DRB Project Number: 2024-010189 Hearing Date: 05-21-2025  
Project: Lot/Tract N1, WATERSHED  
SUBDIVISION  
located on ARROYO VISTA  
between GATEWAY LANE and  
TIERRA PINTADA Agenda Item No: 11

**Project Number:** PR-2024-010189

**Application Number:** MAJOR\_PLT-2025-00003

**Project Name:** 9601 Tierra Pintada Blvd NW

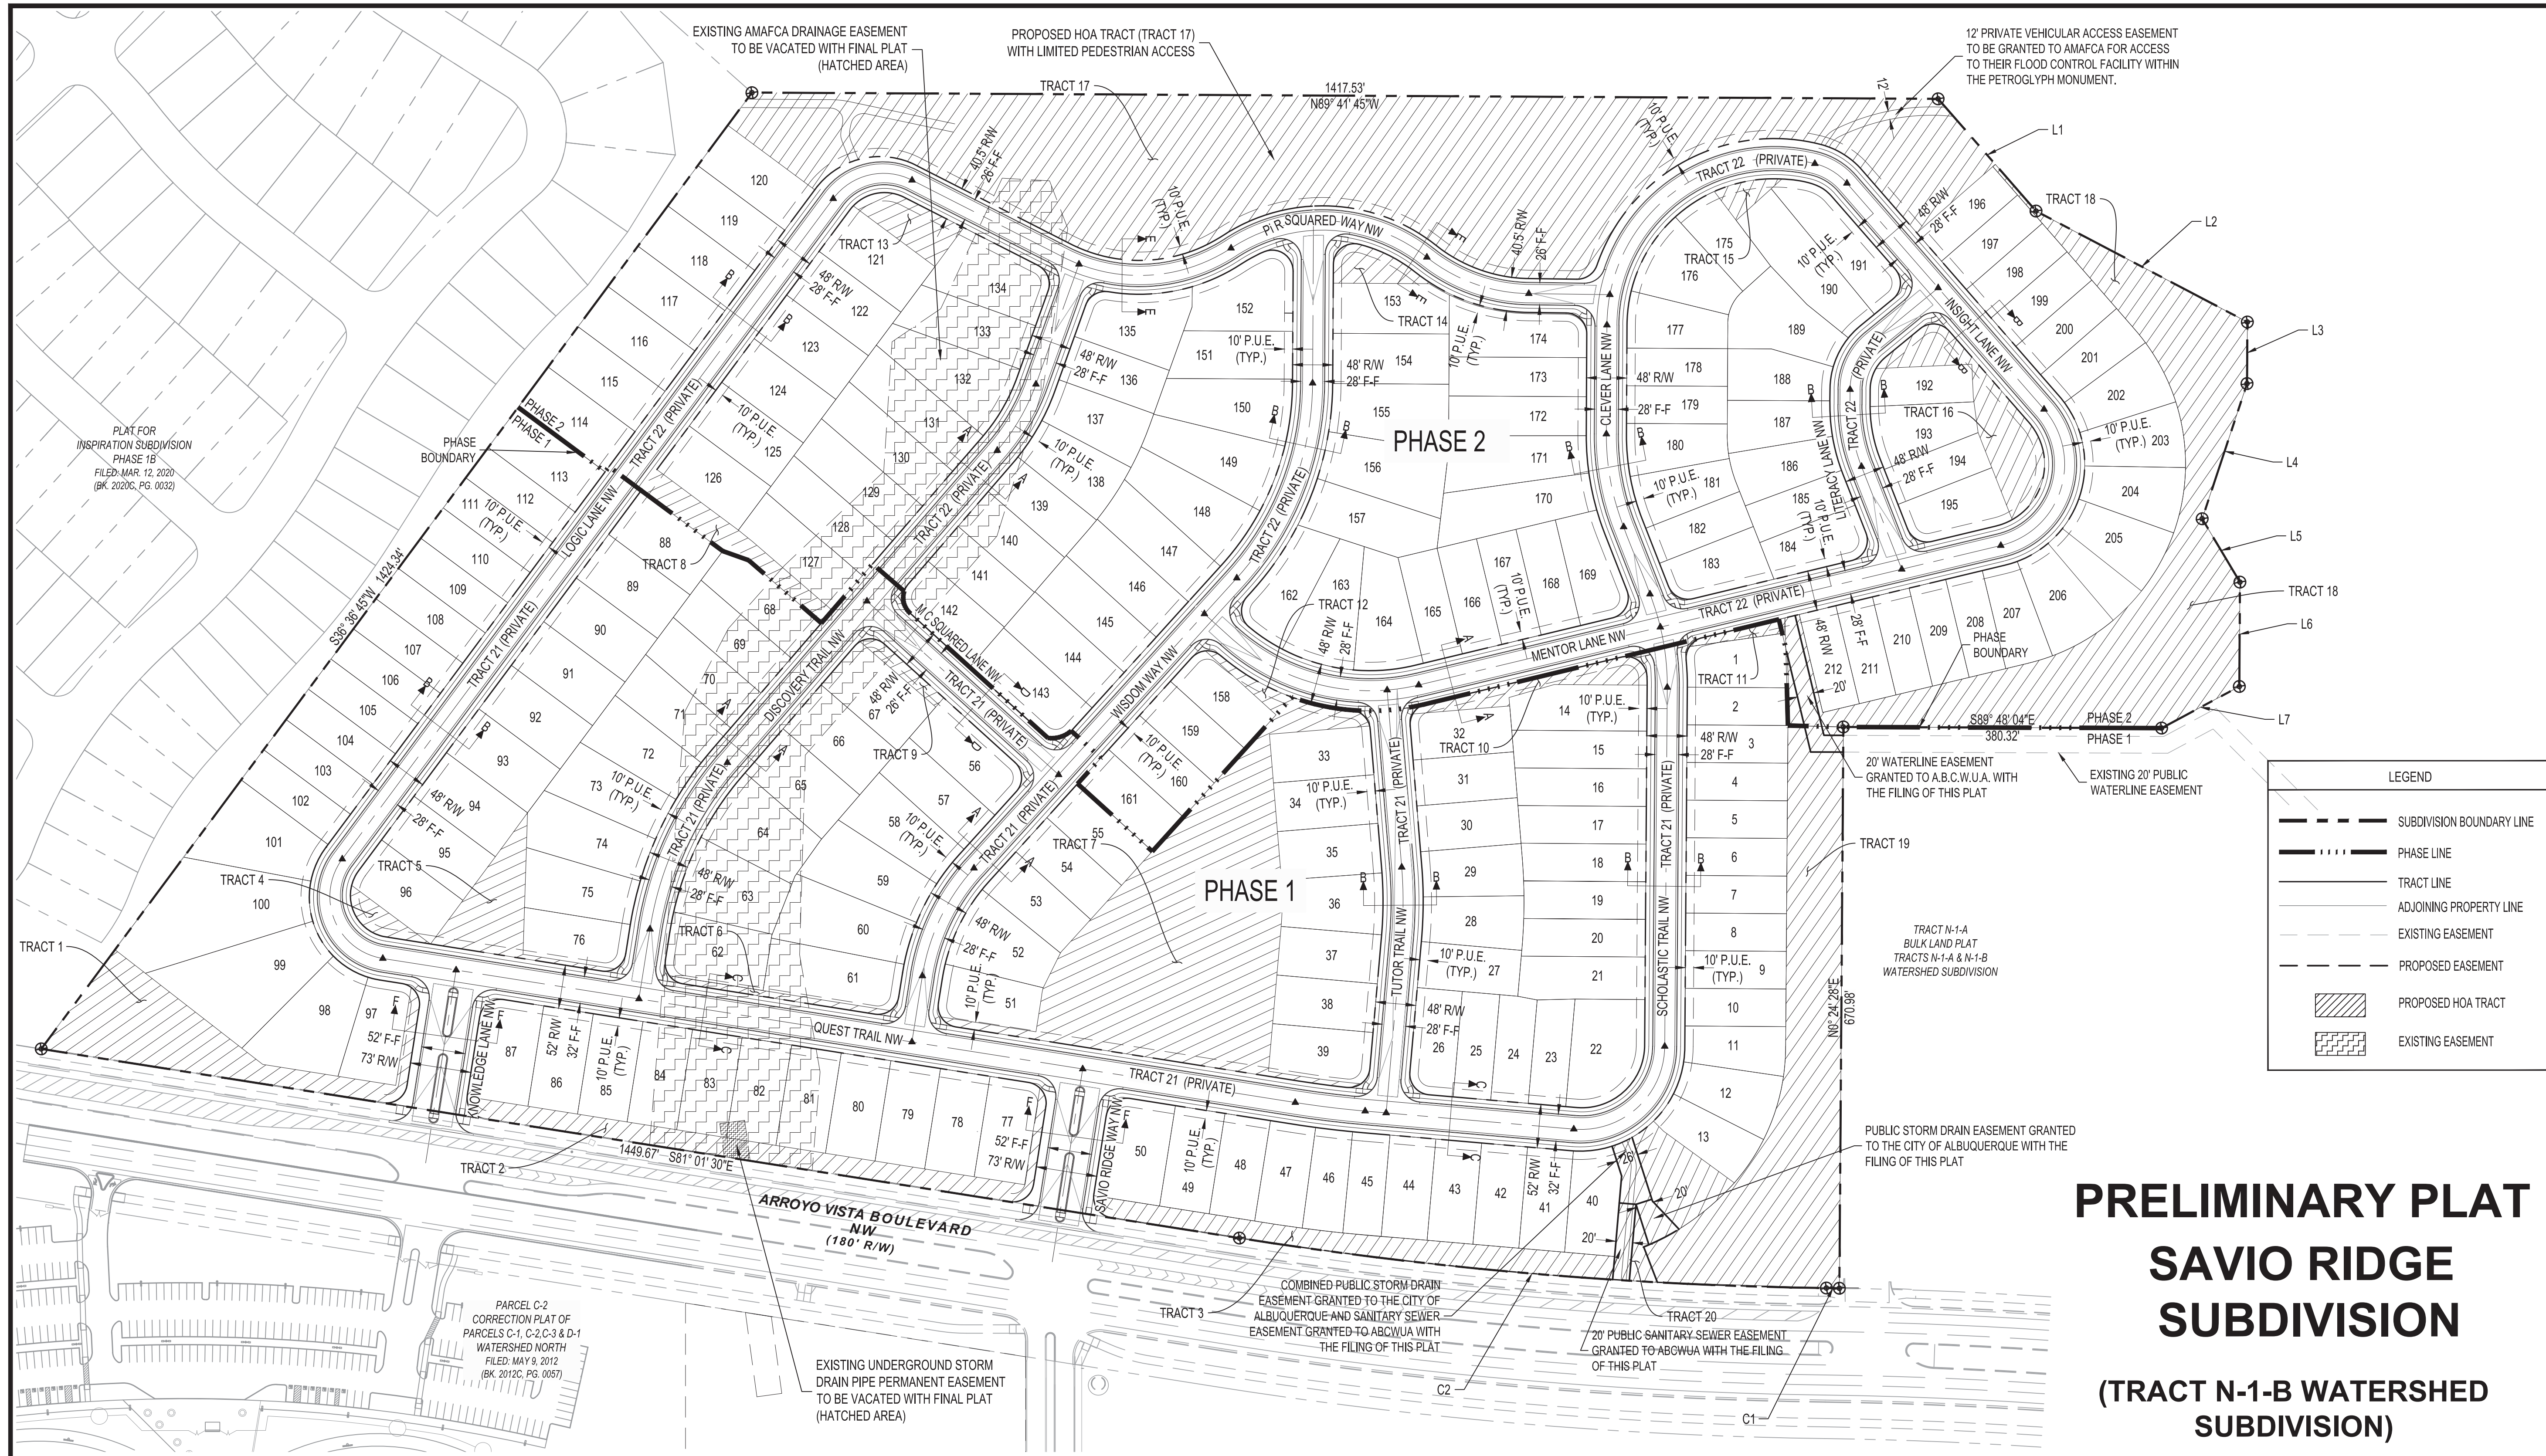
- The DHO Waivers approved at the April 23<sup>rd</sup> DHO meeting must be listed on the Plat per 6-6(P)(2)(d) of the IDO.
- In the North East section of the plat, is the 12' private Vehicular Access Easement to be granted to AMAFCA, the pedestrian trail connection to the Petroglyph National Monument as well?
- Place a note on the Infrastructure List, in regards to the trail along Arroyo Vista, stating that 'any damage that occurs to the trail will be repaired by the developer.' Planning defers on the specific language of the note to Parks and Recreation staff.
- Place the Infrastructure List on the current form. Link provided below:
